DECISION DELEGATED TO DEVELOPMENT MANAGER

Application No: H19-0907-20 **Applicant:** Mr J Plater

Proposal: Extension to existing bungalow and creation of first floor in roof space.
New double garage with loft storage above.

Location: Sunleigh 125 Luttongate Gedney Hill

PROJECT:		
REAR EXTENSION, FIRST FLOOR & DOUBLE GARAGE		
DRAWING:		
PROPOSED FLOOR PLANS PROPOSED ELEVATIONS		
SIZE:	CLIENT:	
A1	Mr J. Plater	
SCALE as labelled	DRAWING BY: JC	SHEET: 0204/20/02B

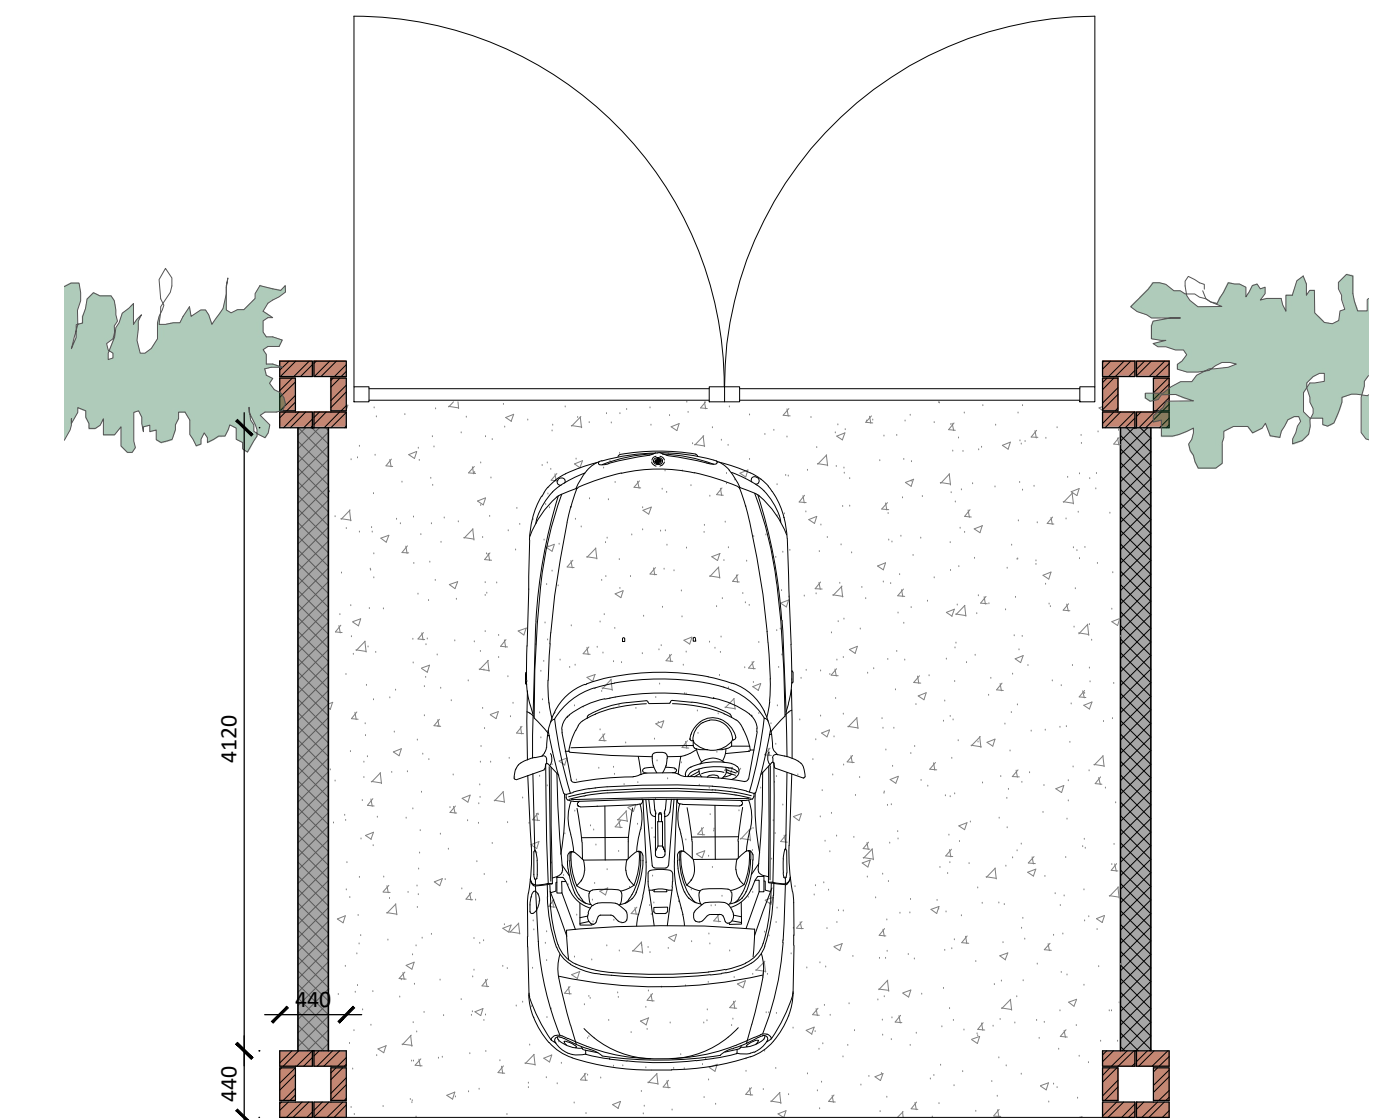
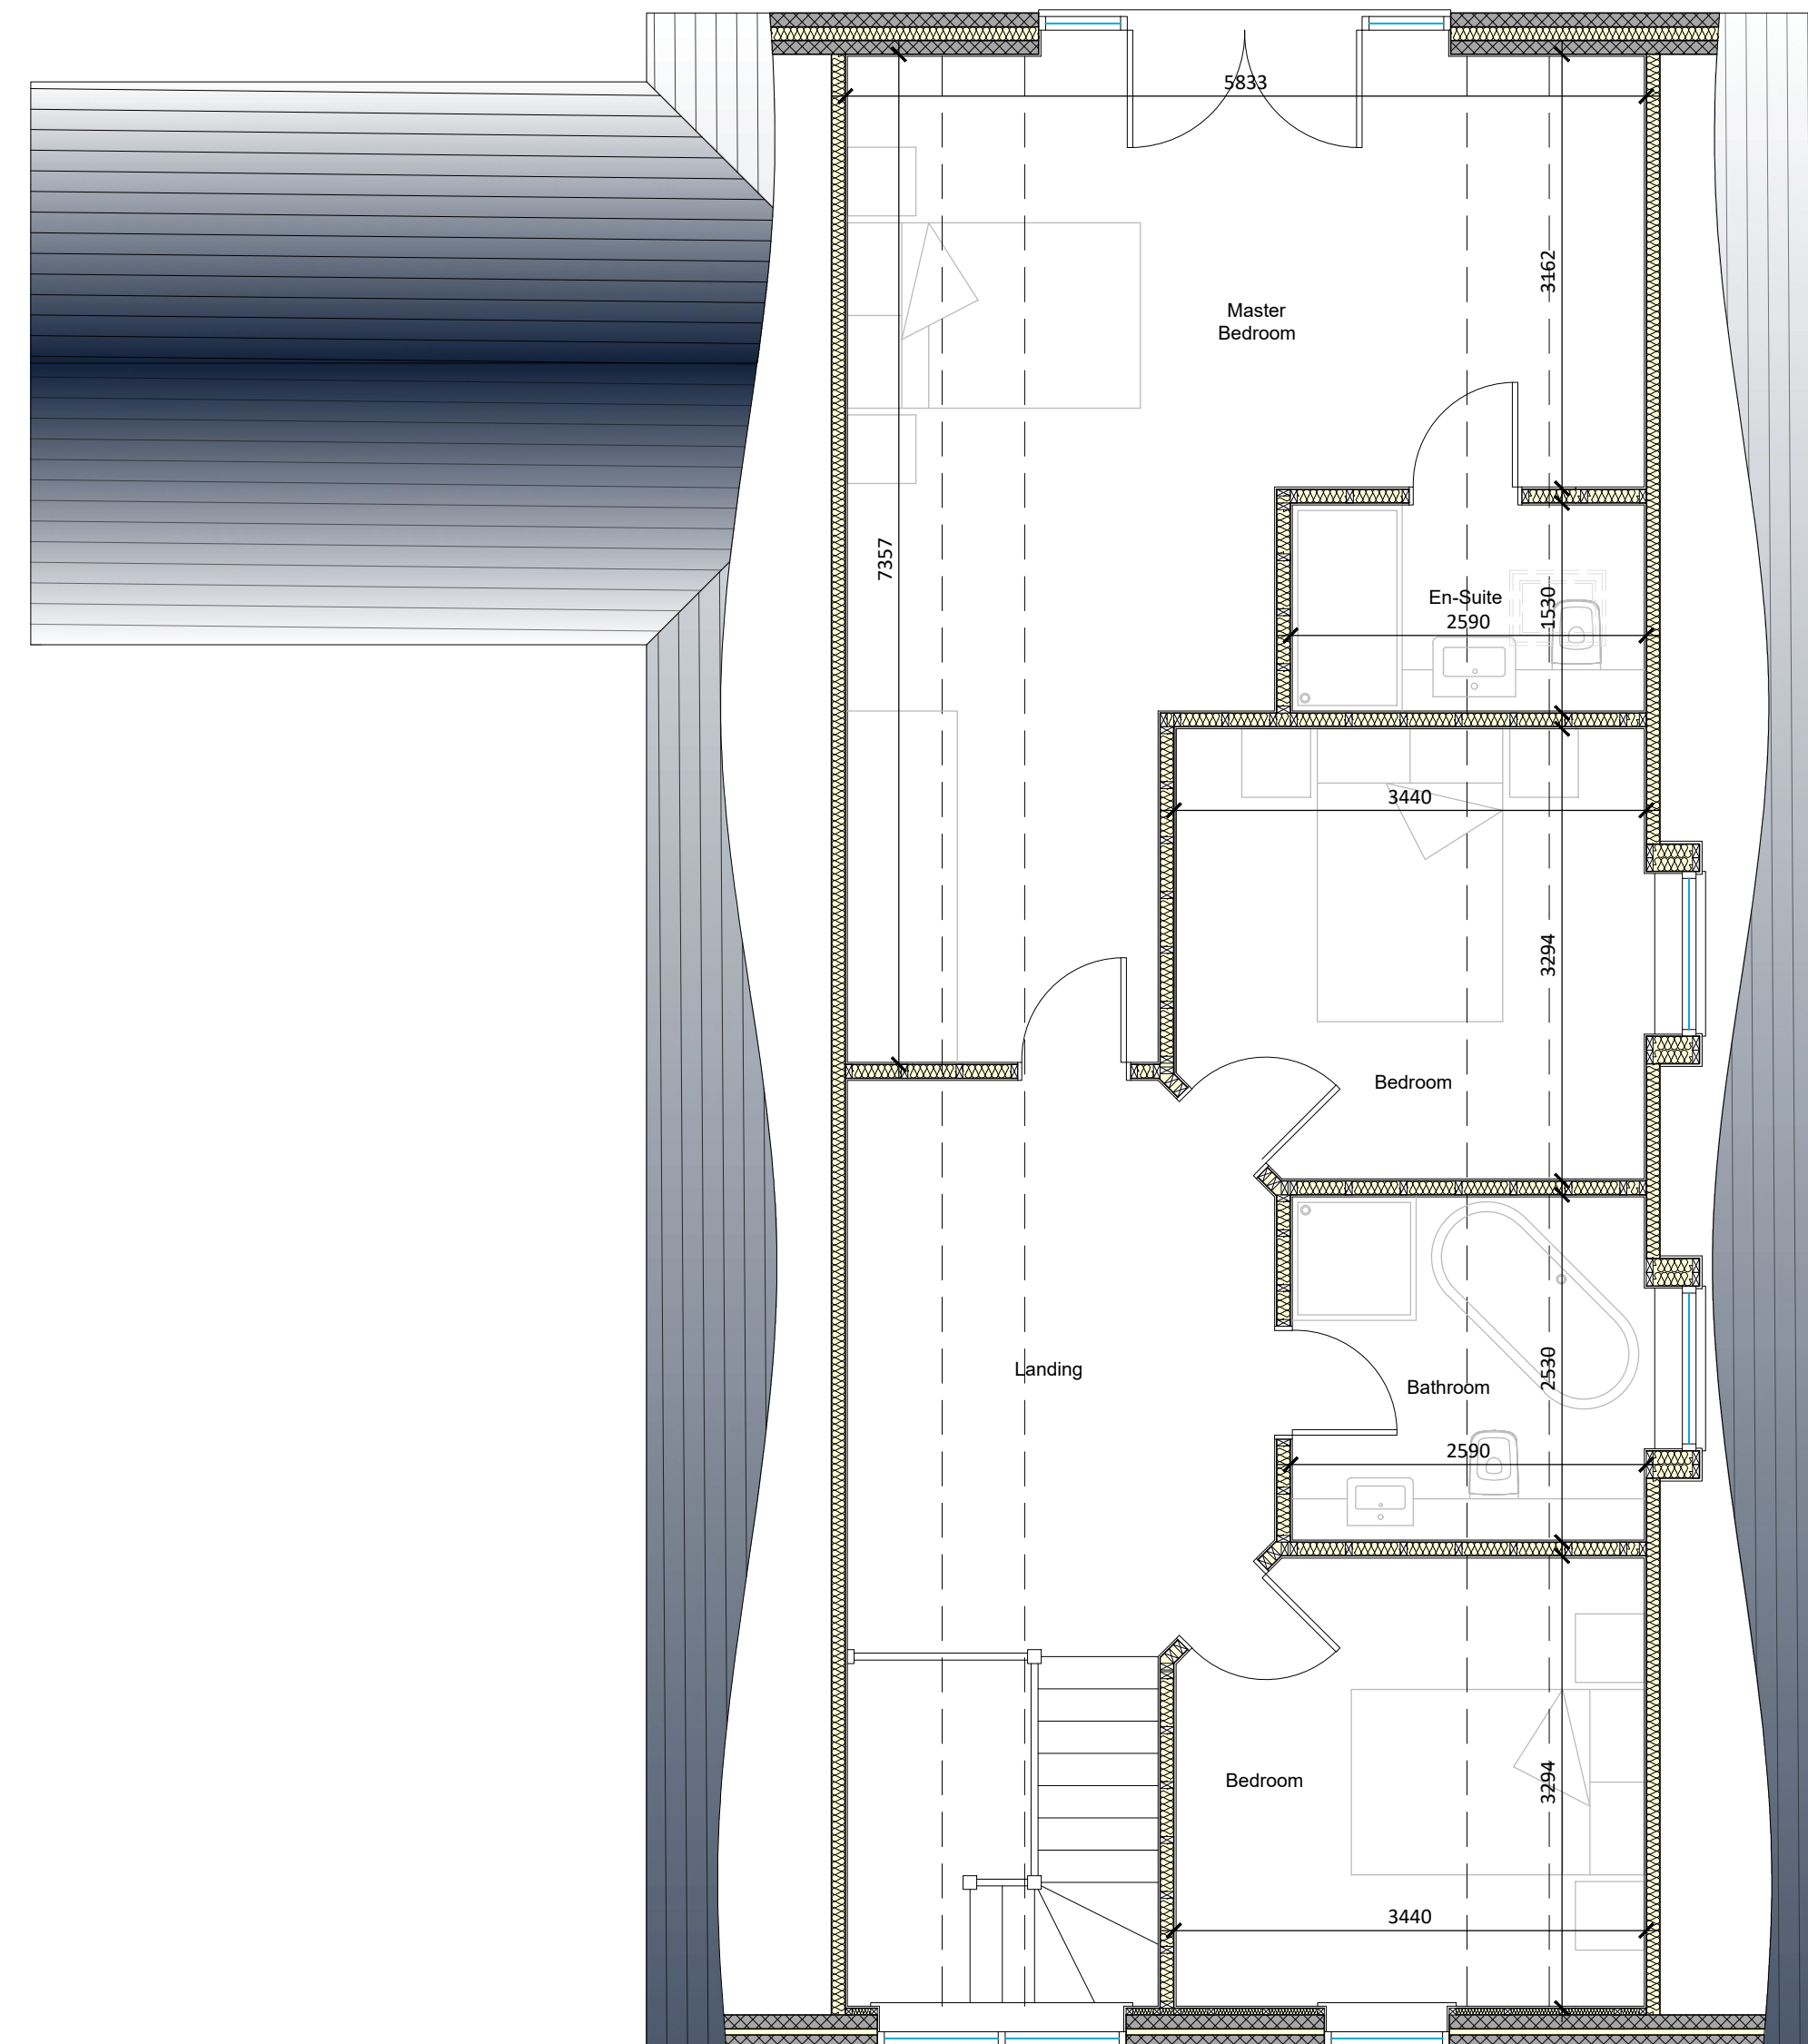
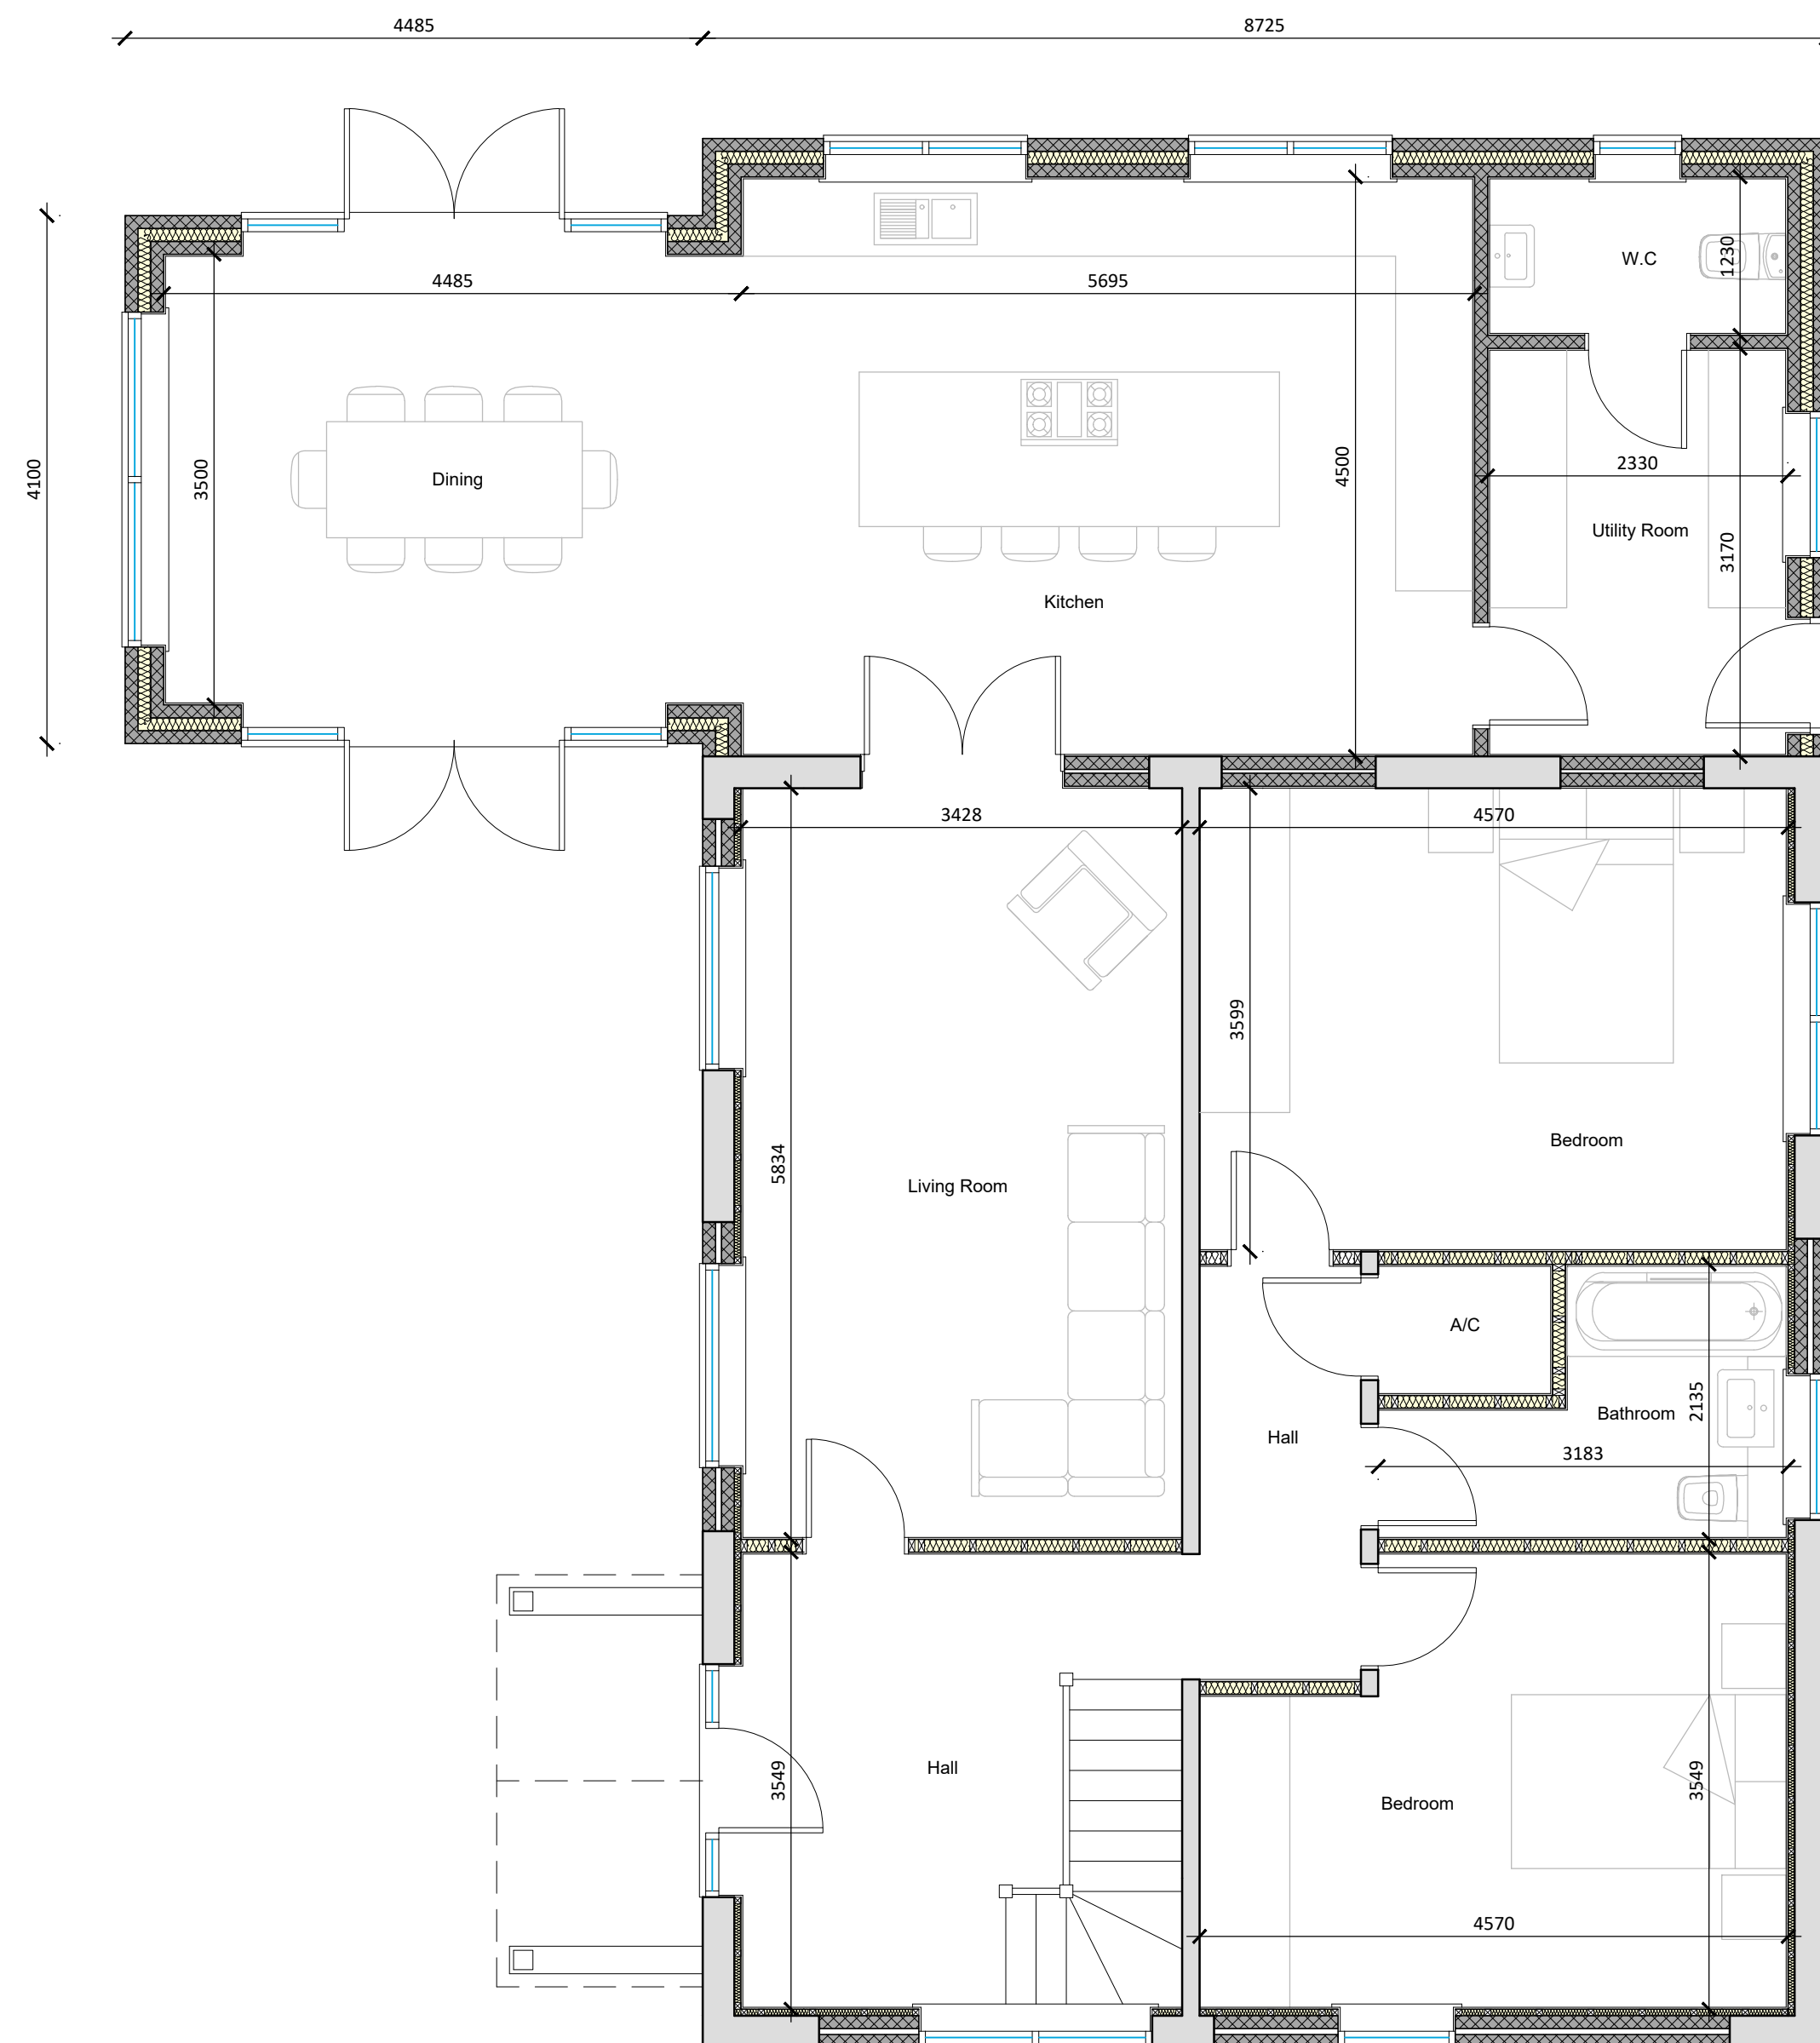
The existing garage near the south-western corner of the bungalow will be demolished to gain further floorspace for the proposed extension. Roofing works are proposed for the main roof of the bungalow in order to replace the hip roof for a gable roof. The pitch height will be marginally increased 70 centimetres up to 7.23 metres.

The proposed extension will protrude 4.48 metres from the southern side elevation of the bungalow. The width will be 4.10 metres. The apex height, 4.93 metres and the eaves, as high as those in the building. As a result of that, the extension will appear subservient to the host property in scale, mass and bulk.

Internally, the increase of the pitch height will ensure sufficient ceiling height to create a habitable loft space within the bungalow. The internal floor layout on the ground floor will be considerably altered although communal spaces and 2 no. bedrooms will remain. The extension will allow to create a large combined dining/open kitchen space. Three bedrooms being one of them ensuite and one bathroom will be provided on the first floor level. In summary, the proposals are in keeping with the residential use of the building

Externally, the entrance door will be relocated from the front elevation to the south-western side elevation. A timber porch on pillars will be erected externally at the frame of the entrance door. In conjunction with the entrance door relocation, the front elevation will be significantly altered. One of the main gable ends will be formed facing the road. Gable fenestration will extend across the front wall. Tantamount window layout will be replicated on the gable wall of the side elevation. On the first floor level, a Juliet balcony will be formed on the rear elevation. Two gable dormer windows are proposed on the north-eastern side elevation.

Turning into the visual appearance of the building, the current brickwork will be rendered in white on all elevations. The existing clay tiles will be replaced for faux blue slate. White UPVC will be replaced for identical material but in grey. In contrast, facing brickwork is proposed for the detached garage. The proposed material schedule will significantly upgrade the appearance of the dwelling without harming the character of the area. The few properties on the vicinity were individually designed and there is no well-defined pattern of appearance.
